May 22, 2015

RE: 72 Bishop Street

The following documentation and supporting information have been prepared in response to staff review comments received on May 12, 2015 and May 13, 2015, responses are in **Italic**.

1 POROUS PAVERS & R-TANK STORMWATER SYSTEM  
NOT TO SCALE

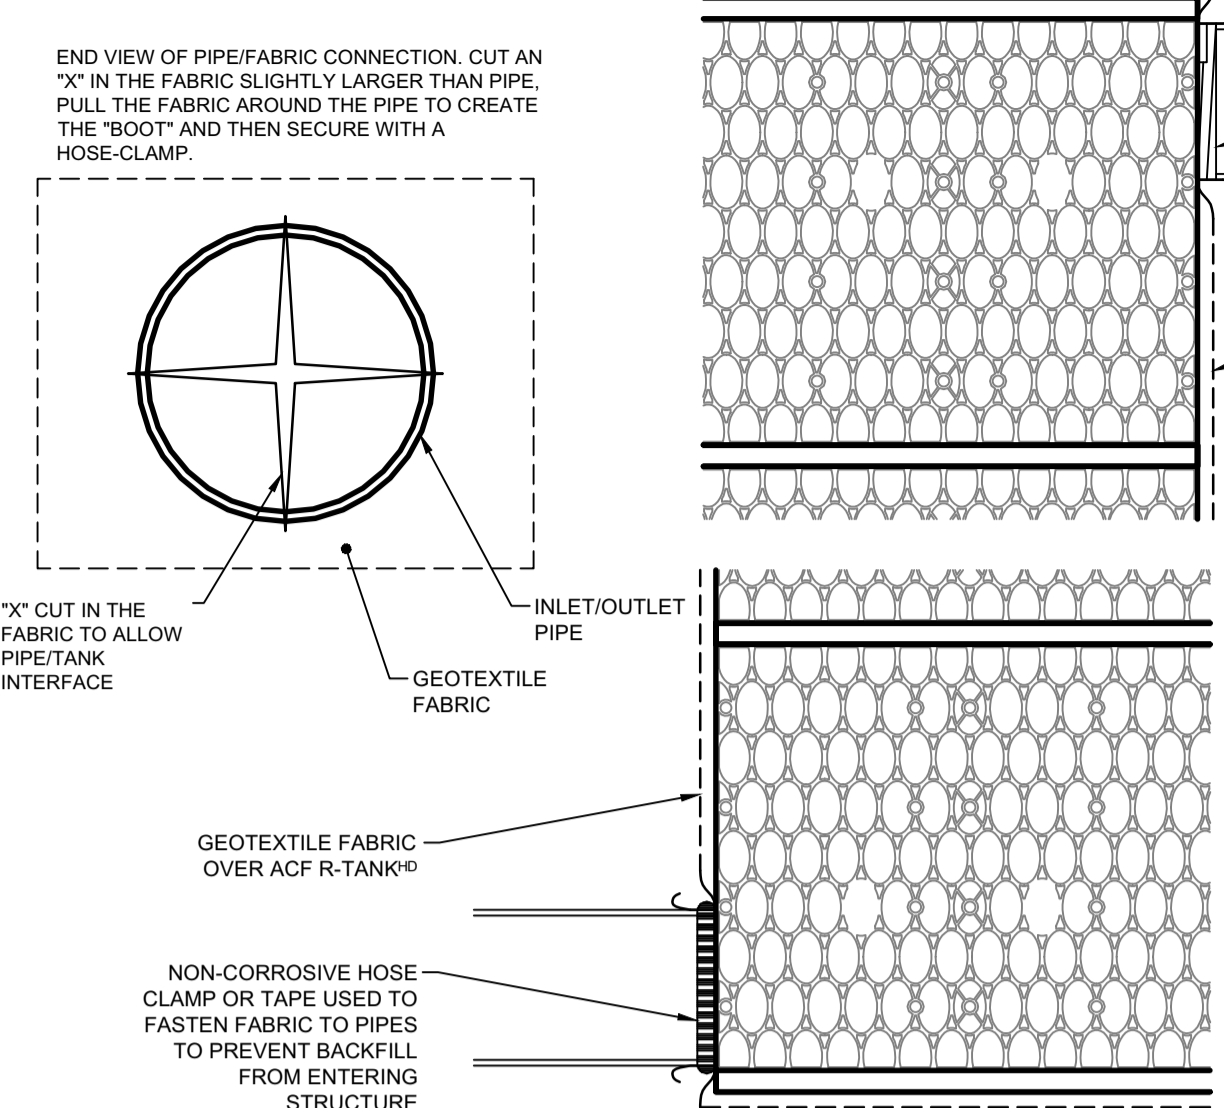
7. The Applicant has proposed a porous paver strip along the proposed retaining wall, which exceeds five feet in height. A geotechnical report has been provided that specifies the parameters for the wall design engineer; however, at this time, the geotechnical report does not appear to include an evaluation of the impact of the porous pavement and associated R-Tank storage system on the wall design. The Applicant should clarify whether infiltration from the porous pavers adjacent to the proposed retaining wall and the adjacent below grade stormwater storage has been evaluated/considered by the geotechnical engineer.

8. The R-Tank system does not appear to be lined with a water tight liner.

The Applicant requested SW Cole Engineering, the project geotechnical engineer review the details and they provided the following recommendations. To address potential impacts from frost conditions on the wall, they have recommended that the R-Tank system be located a minimum of 4.5 feet from the back of the retaining wall. We have revised the plans and details accordingly.

Detail 1 Sheet L7 has been revised to show the use of 20 mil poly liner that extends along the back of the retaining wall and wraps the R-Tank system.

8 VEGETATED SOIL FILTER (WEST SIDE OF BUILDING)  
NOT TO SCALE

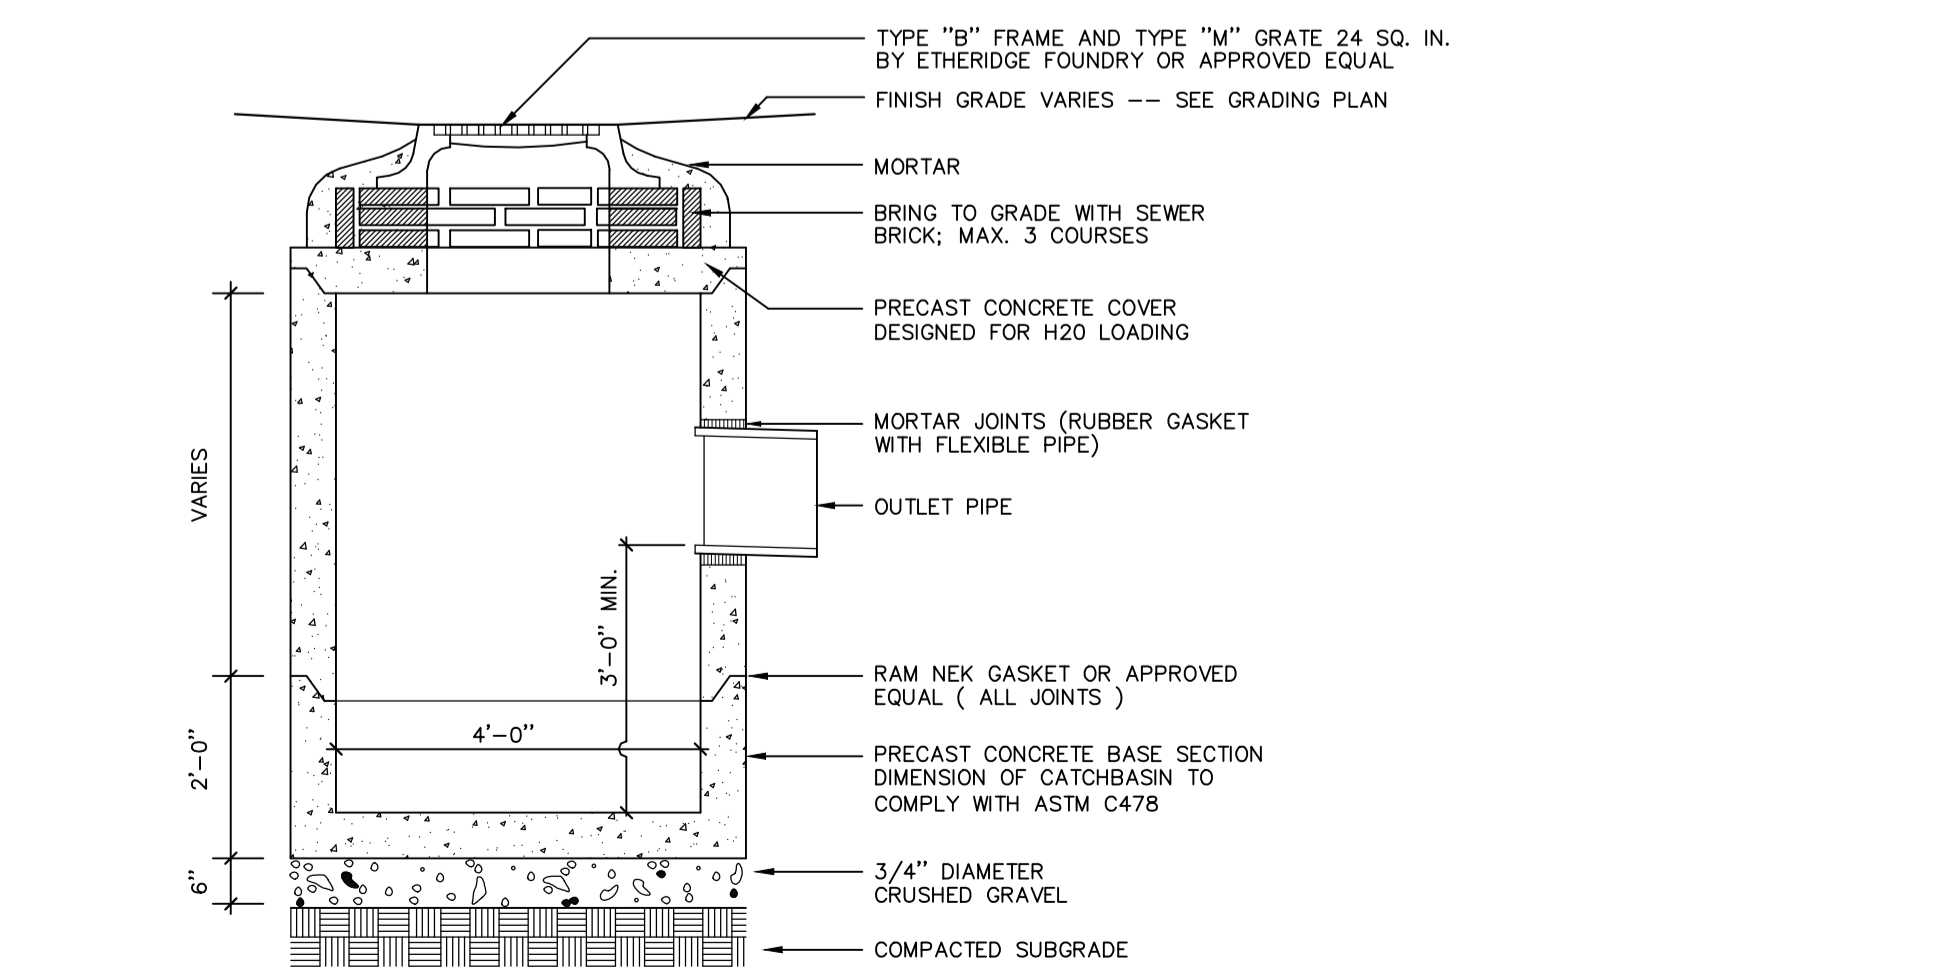
9. Outlet Control Structure outlet protection and J-drain connection.

The stormwater design has been modified to construct a vegetated soil filter with a perforated 6 inch drain pipe that will connect to the Outlet Control structure. Refer to detail 8/L7.

3 PRECAST CONCRETE CATCHBASIN  
NOT TO SCALE

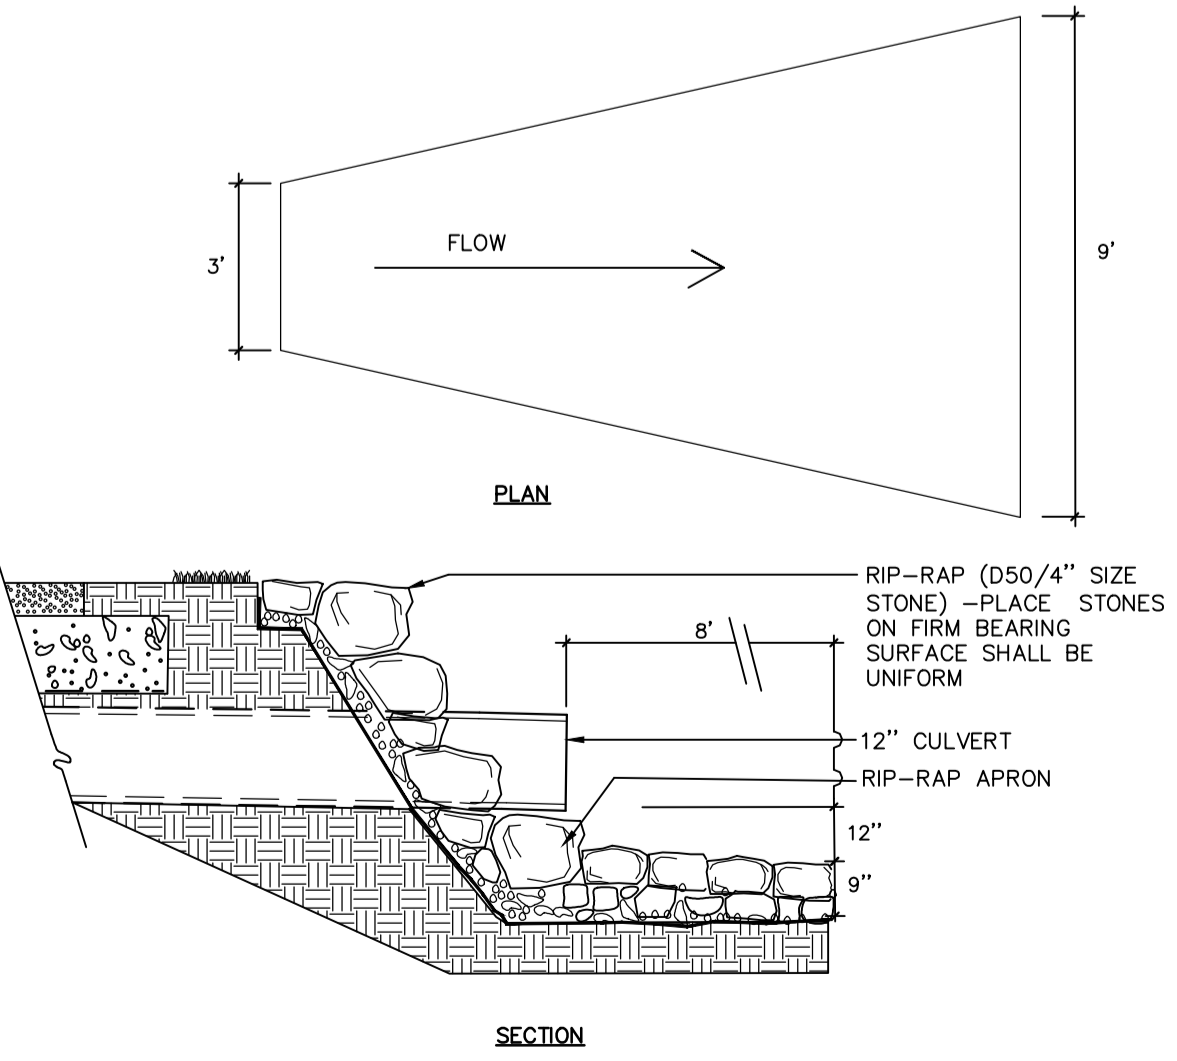
9. All catchbasins capturing stormwater discharging into an urban impaired watershed, the applicant is requested to install four foot diameter catchbasins with three foot sumps.

Catch basin Detail 3/L7 has been added to the site details.
